Subject: **Neuse River Buffer Authorization Modification Request** for US 70 (Clayton Bypass) from I-40 to US 70 Business in Wake and Johnston Counties, State Project No. 8.T311002, TIP No. R-2552, NCDOT Divisions 4 and 5, WBS Element 34459.1.1.

Reference: Neuse River Buffer Authorization dated January 14, 2005 (WQC Project No. 041760)

**GRADING AND DRAINAGE
EROSION CONTROL FOR
CONSTRUCTION SHEET 10**

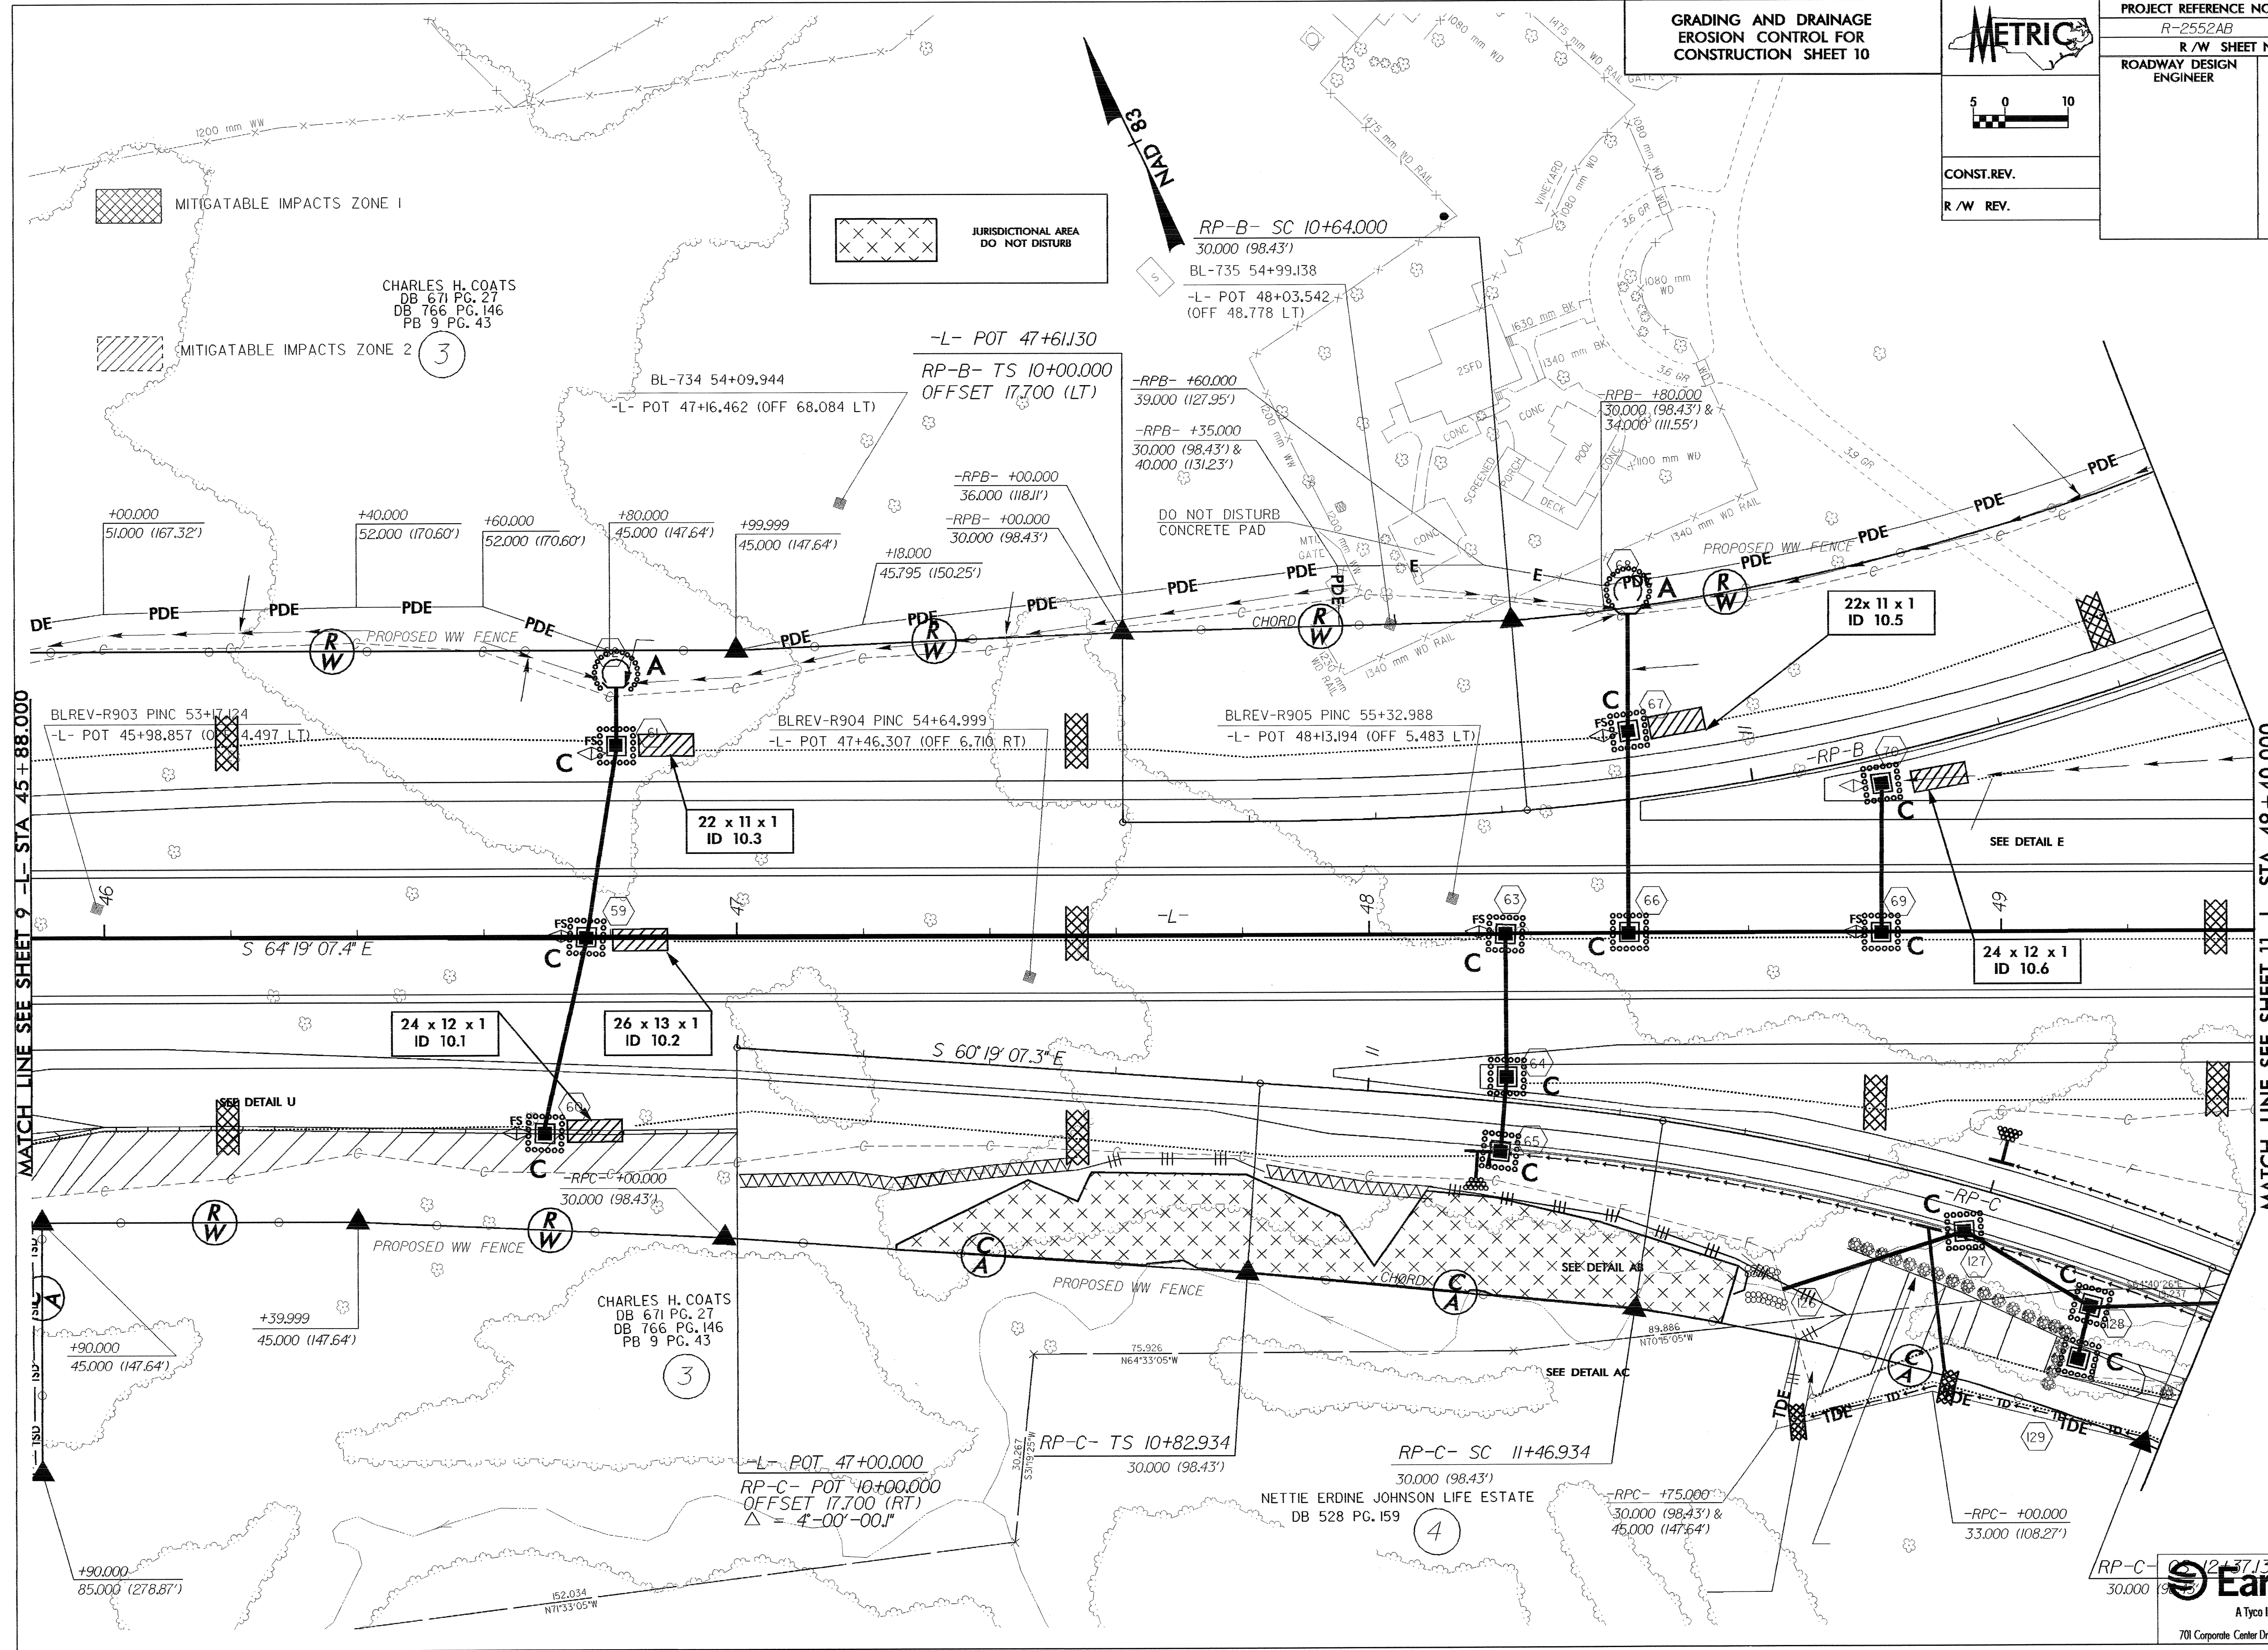
There are two issues in particular at this site (see attached map). There are additional impacts to Buffer Zone (BZ) 1 and 2 that can easily be seen within the slope stake line when reviewing Roadway Plan Sheet # 10. Those impacts are a continuation off the end of Site AB5d. However, in reviewing the general area along Ramp C, the blue-line stream has apparently meandered closer to the proposed Ramp C in some locations thereby requiring additional impacts to BZ2. The attached drawing indicates the field located BZ1 and 2, and highlights the existing and proposed impacts at this location. These revisions account for a reduction of 129.50 square ft of riparian buffer impacts in Zone 1 and an increase of 1463.82 square ft of riparian buffer impacts in Zone 2. No additional mitigation is proposed since the impacts at each site are not equal to or exceed 0.3 ac or 150 linear ft.

PROJECT REFERENCE NO. R-2552AB	SHEET NO. EC-10/CONST.10
R/W SHEET NO.	HYDRAULICS ENGINEER
ROADWAY DESIGN ENGINEER

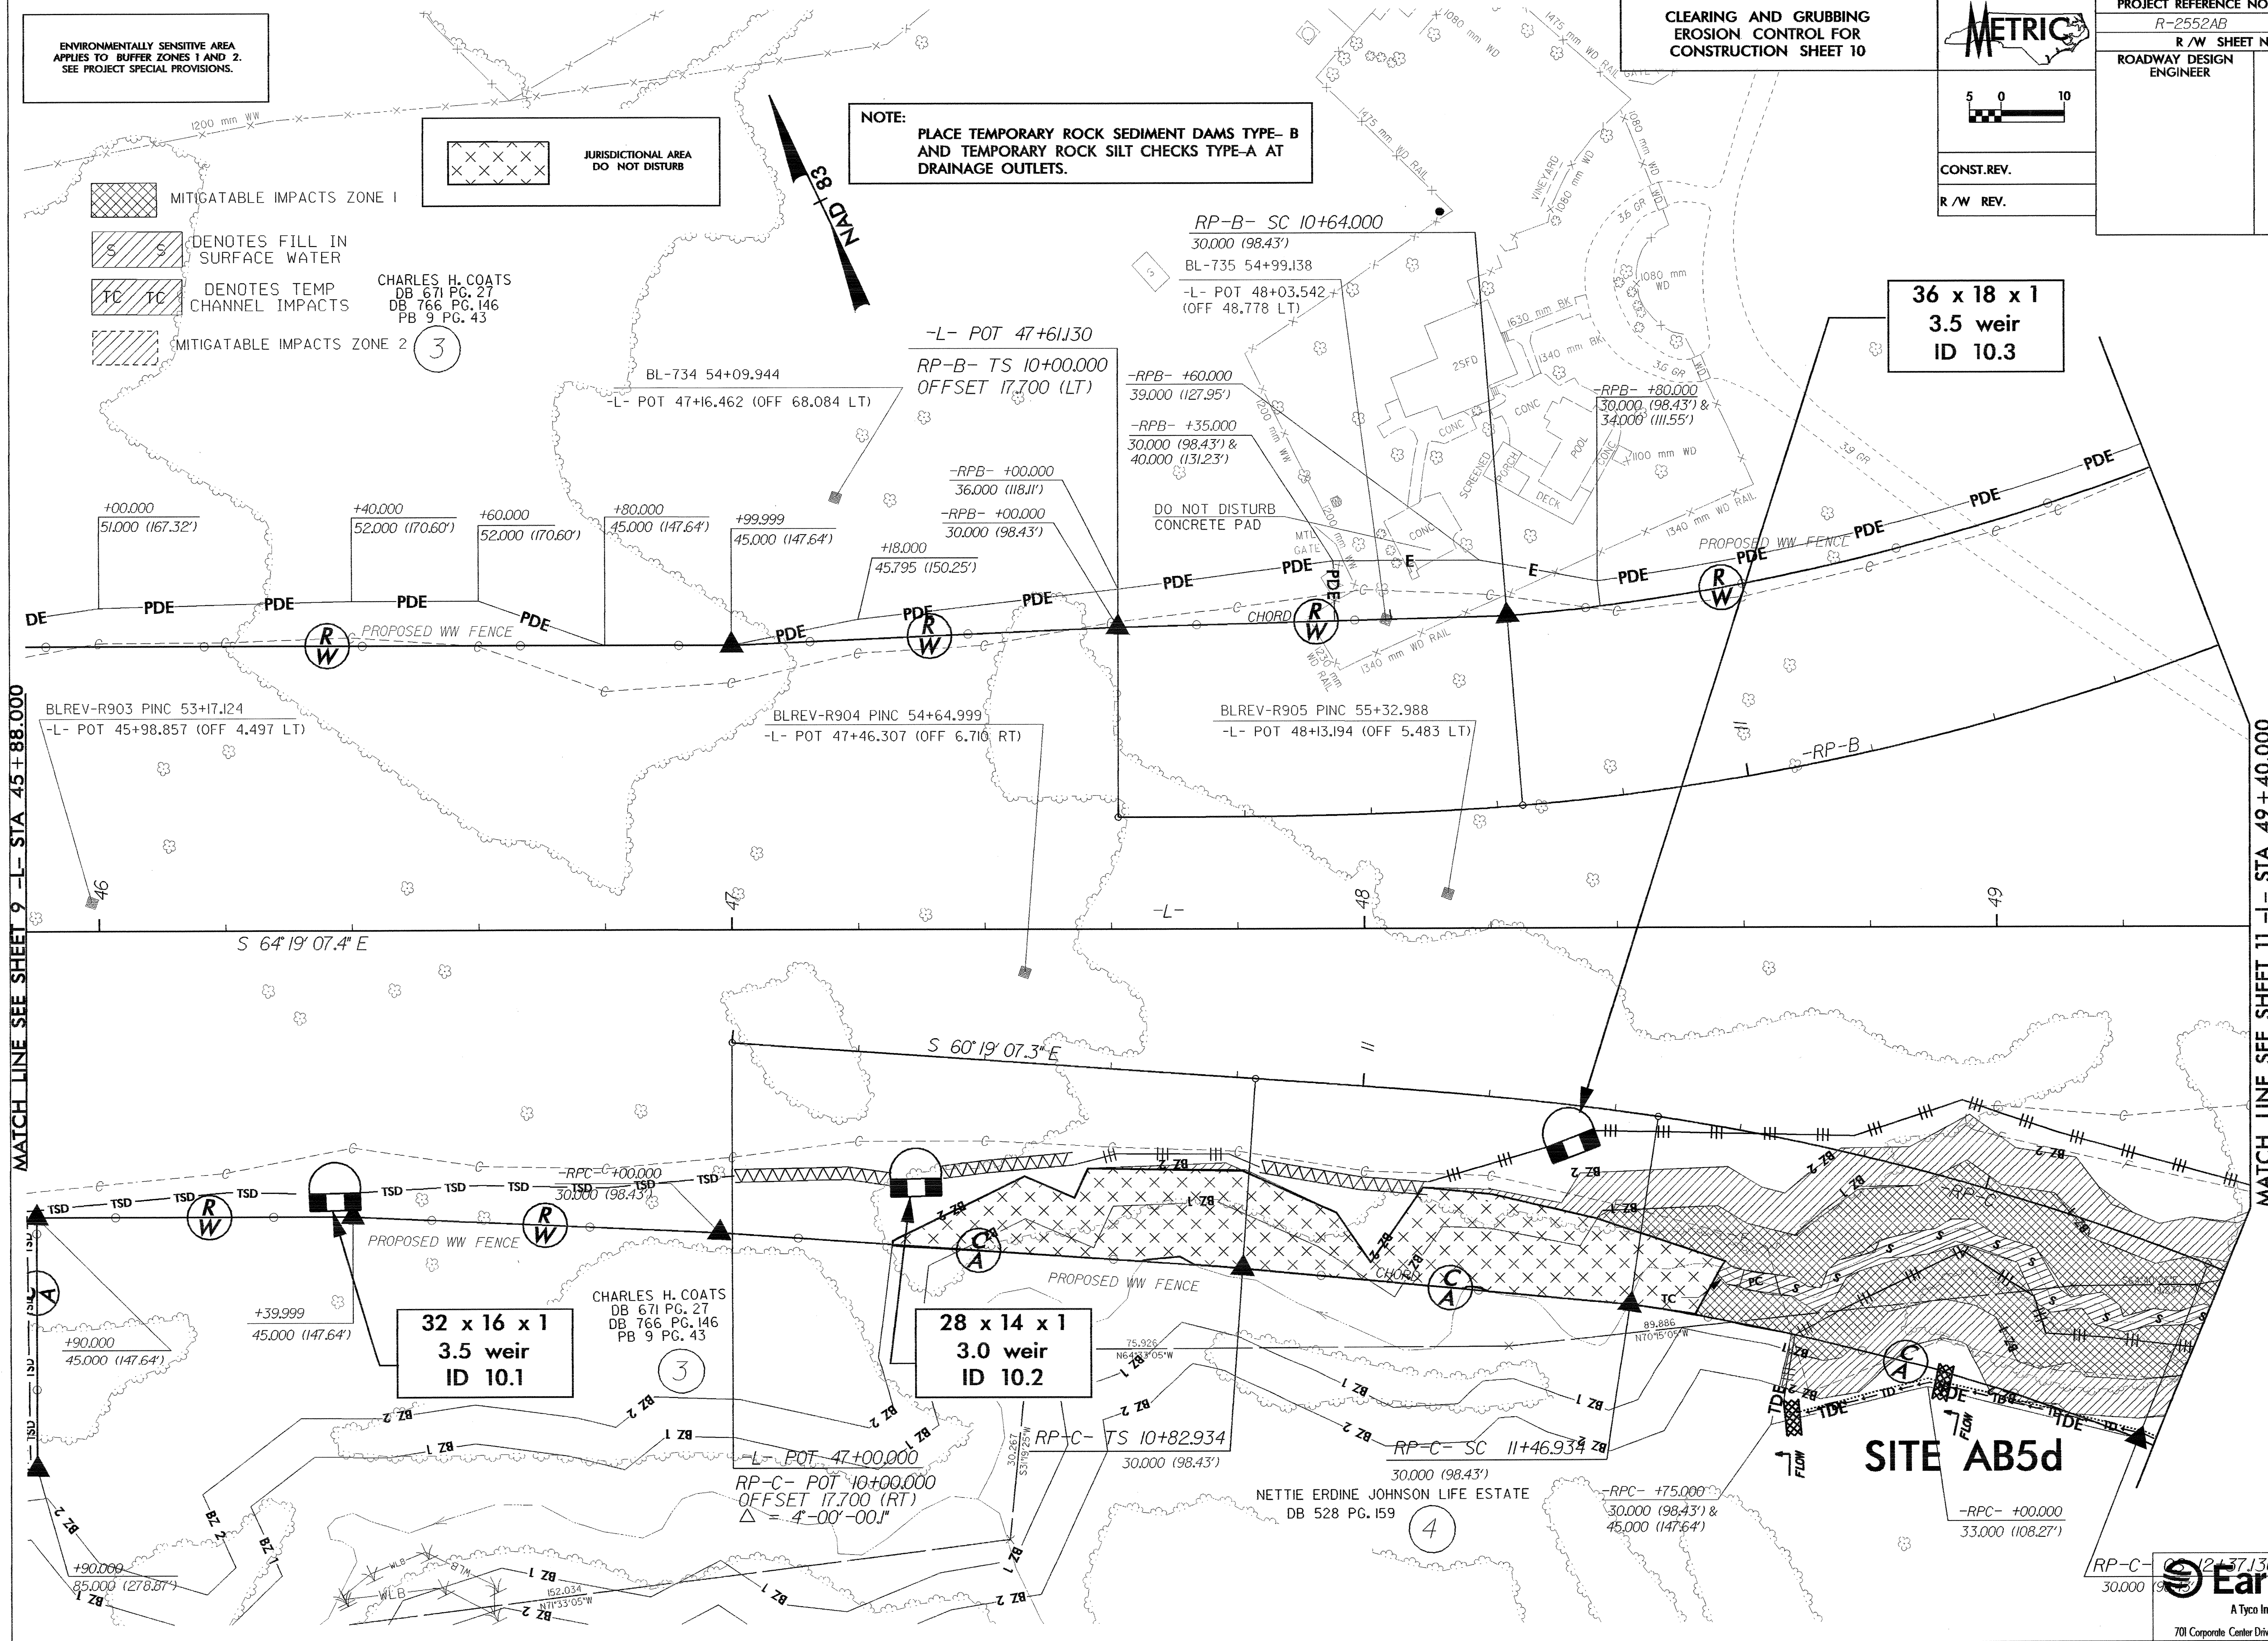
It appears that a site was inadvertently omitted from the Neuse River Buffer permit drawings on the R-2552AB project along Ramp C at the NC 42 interchange. The specific site is a continuation of Site AB5d.
